**MAJOR PROJECTS ASSESSMENT:
Commercial/Retail Building
Lot 1 DP 301489
92 Manning Street, Tuncurry
Proposed by Coastplan Consulting**

Director-General's
Environmental Assessment Report
Section 75I of the
Environmental Planning and Assessment Act 1979

November 2009

SCALE:	DRAWN BY:	PLOT DATE:	CHECKED:	QA:
1:100	@A1 MB	27/07/2009		
PROJECT NUMBER:	DRAWING NUMBER:	ISSUE:		
06055	DA-04	A

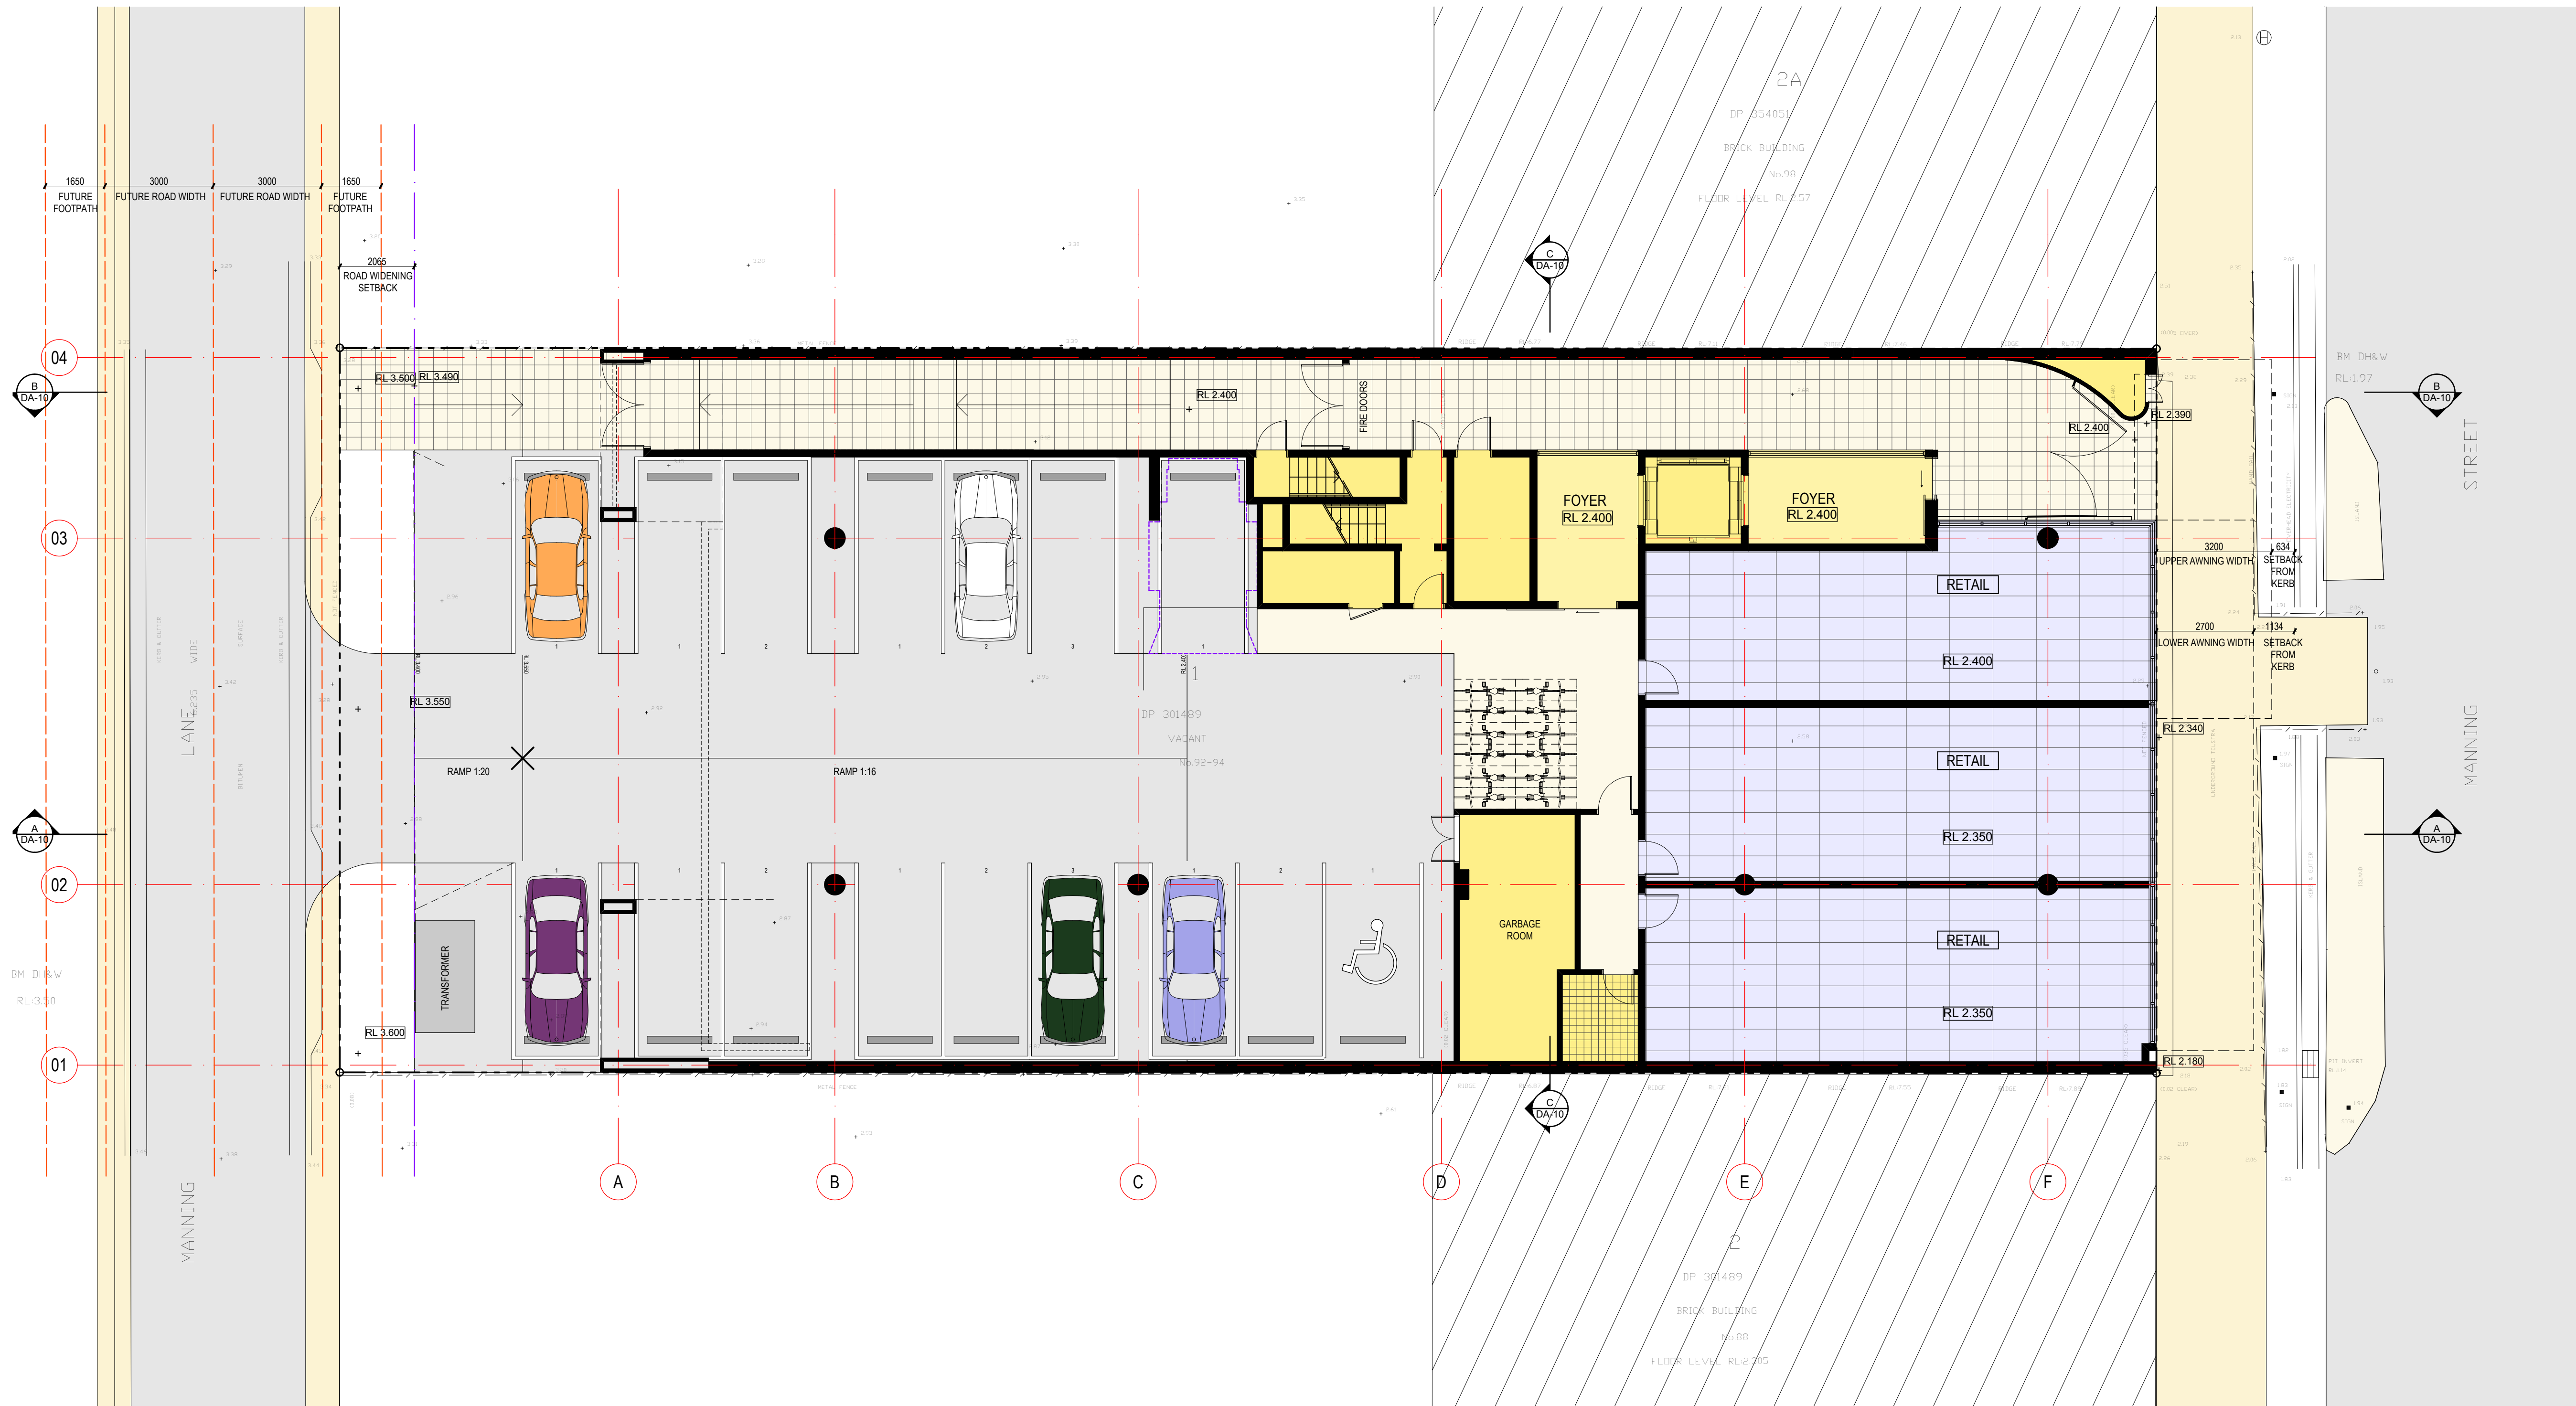
Council has advised that the traffic generated by the proposed development will require the ultimate widening of Manning Lane to cater for two-way traffic. This requires a dedication of a minimum 2.064 metre strip of land along the Manning Lane site frontage. The required dedication is appropriately shown on the plans and is illustrated in Figure 7.

Level 1
SCALE 1:100

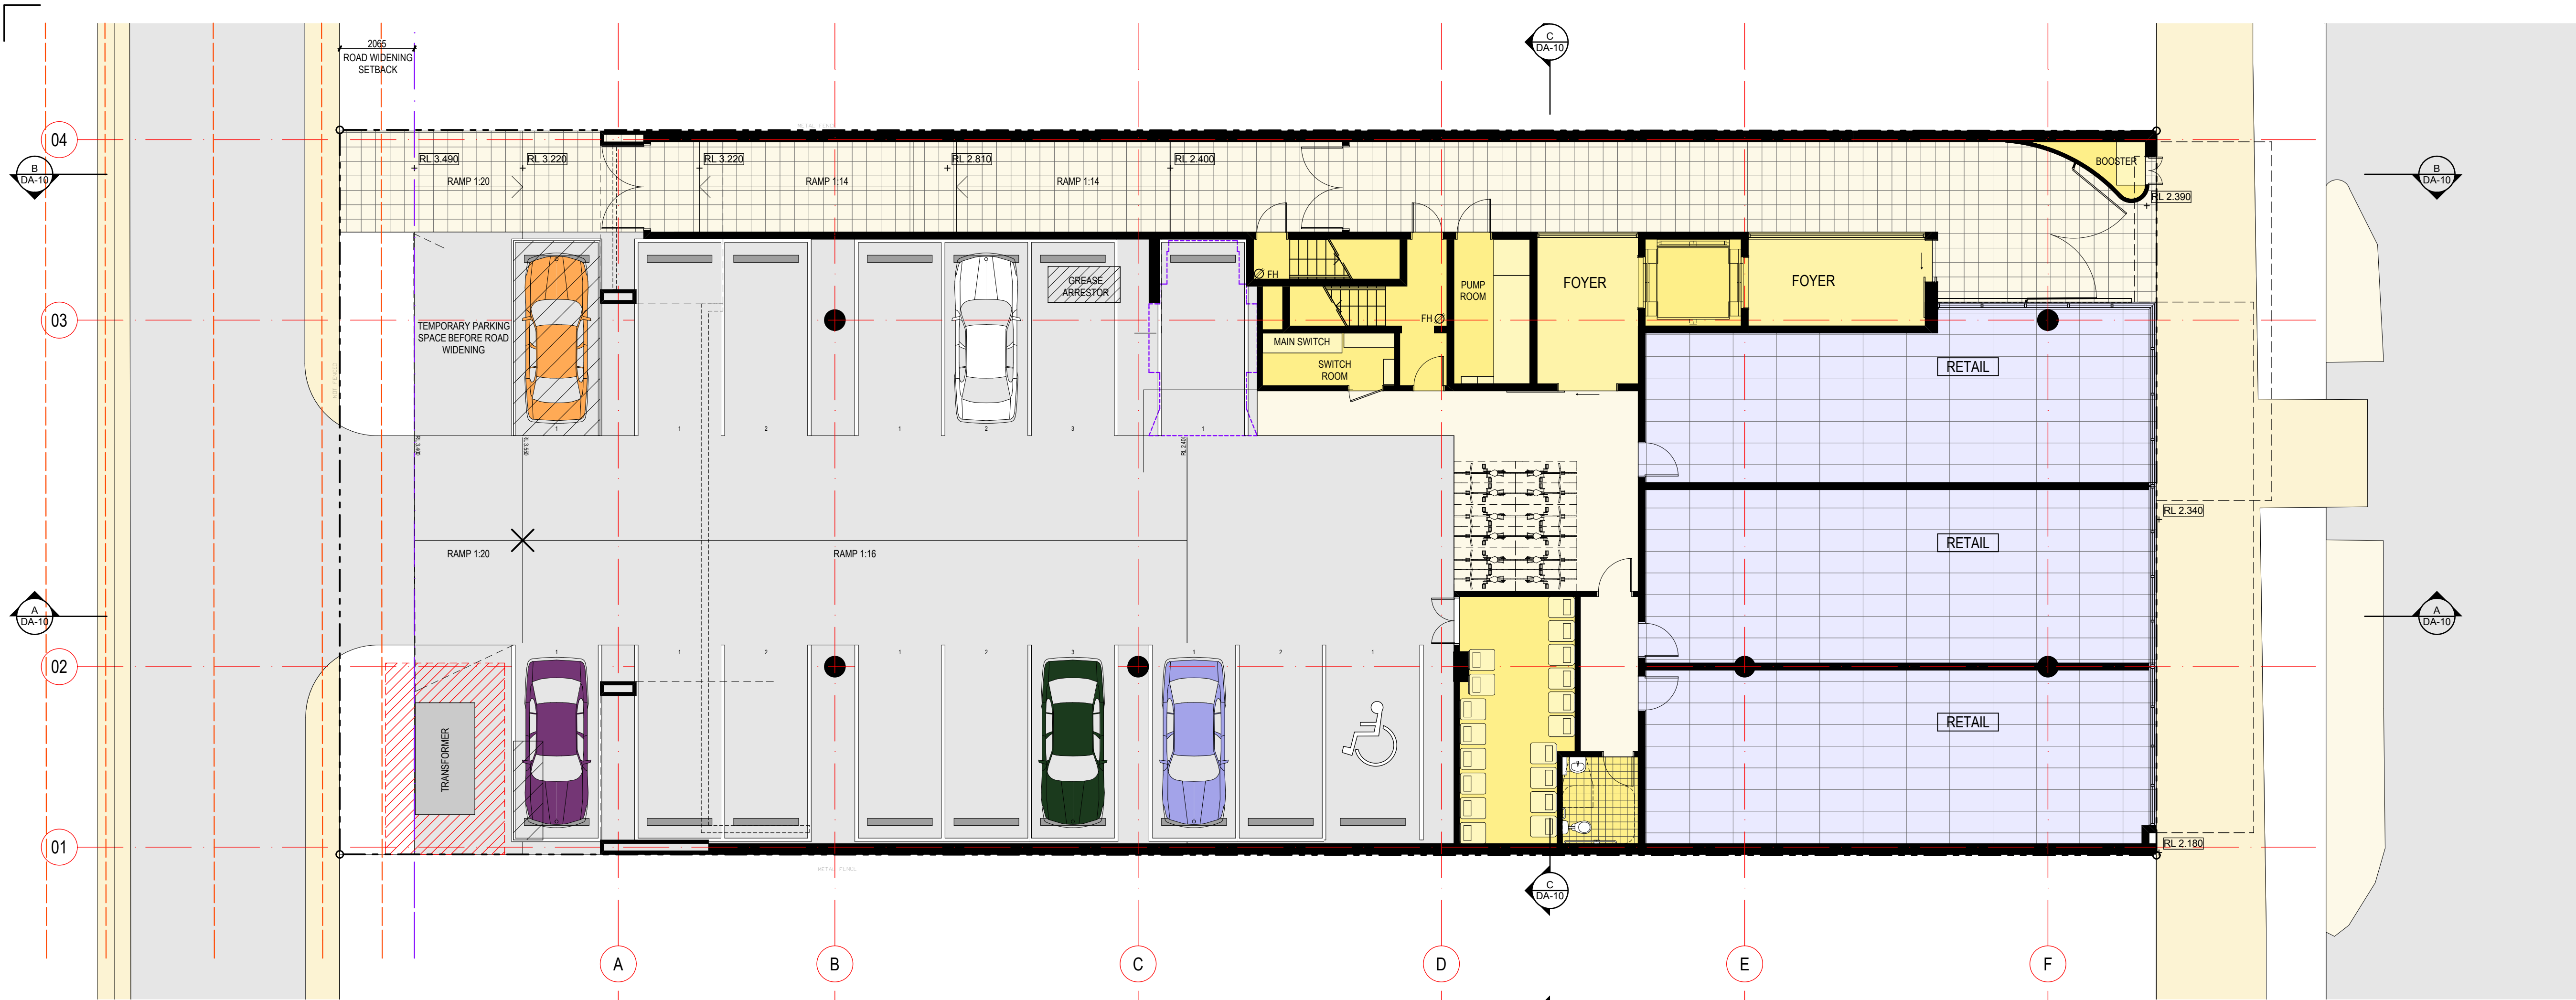
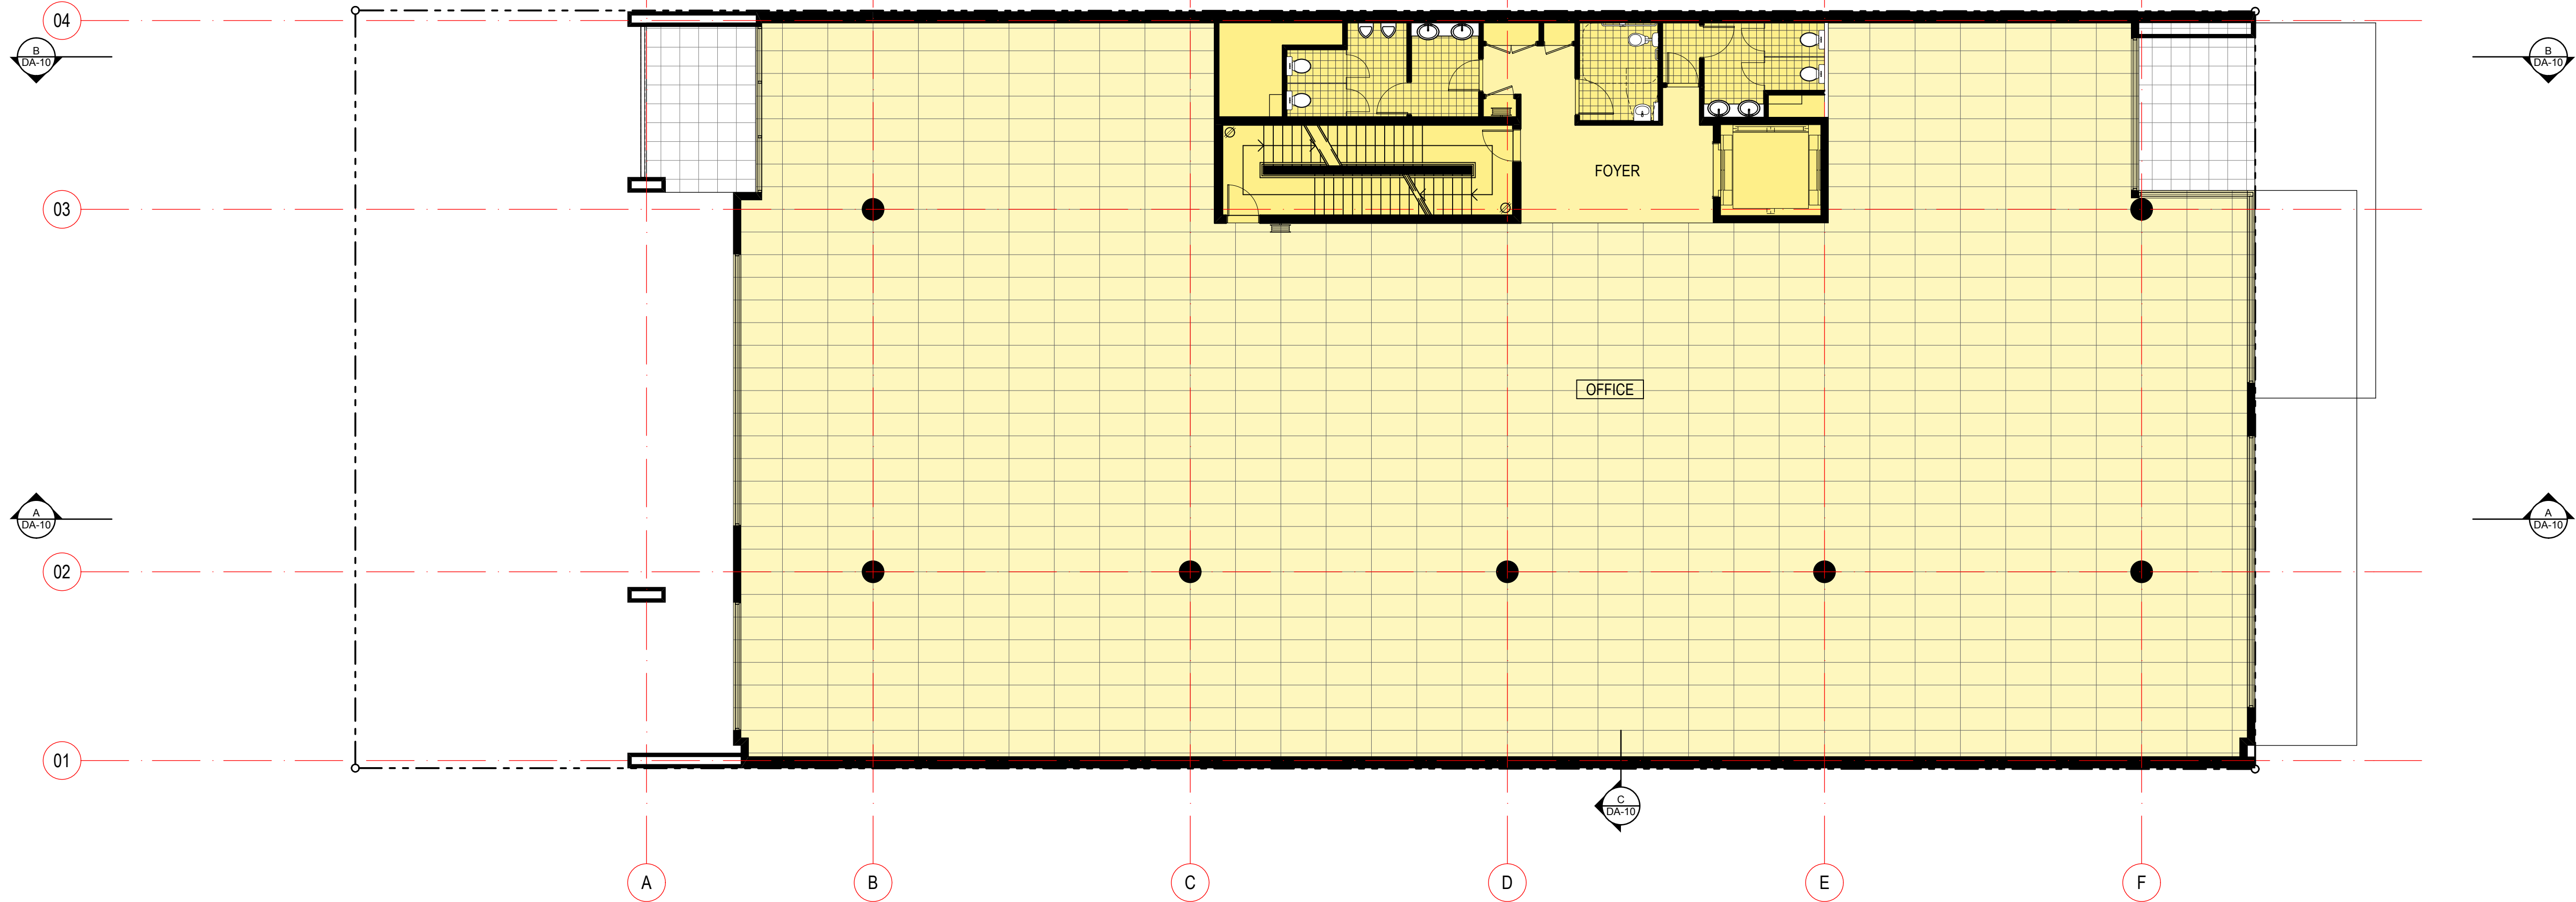
In terms of design, the three retail shopfronts should be accessed directly from Manning Street in order to promote the street activation envisioned in the Town Centres DCP. On the provided drawings the only access shown to these shops is from a small foyer to the rear. The elimination of this foyer would also allow the retail tenancies to be enlarged. This requirement shall be reflected in the recommended conditions of approval (if approved).

Council has raised concerns regarding access to the site for delivery vehicles. It is noted that there is not enough room for a delivery truck to do a three point turn within the car parking area and the truck will be required to exit the site by reversing. Due to the site constraints, Council recommends a condition that requires deliveries are made on site within the aisle of the car park and line marking is provided accordingly. This requirement shall be reflected in the recommended conditions of approval.
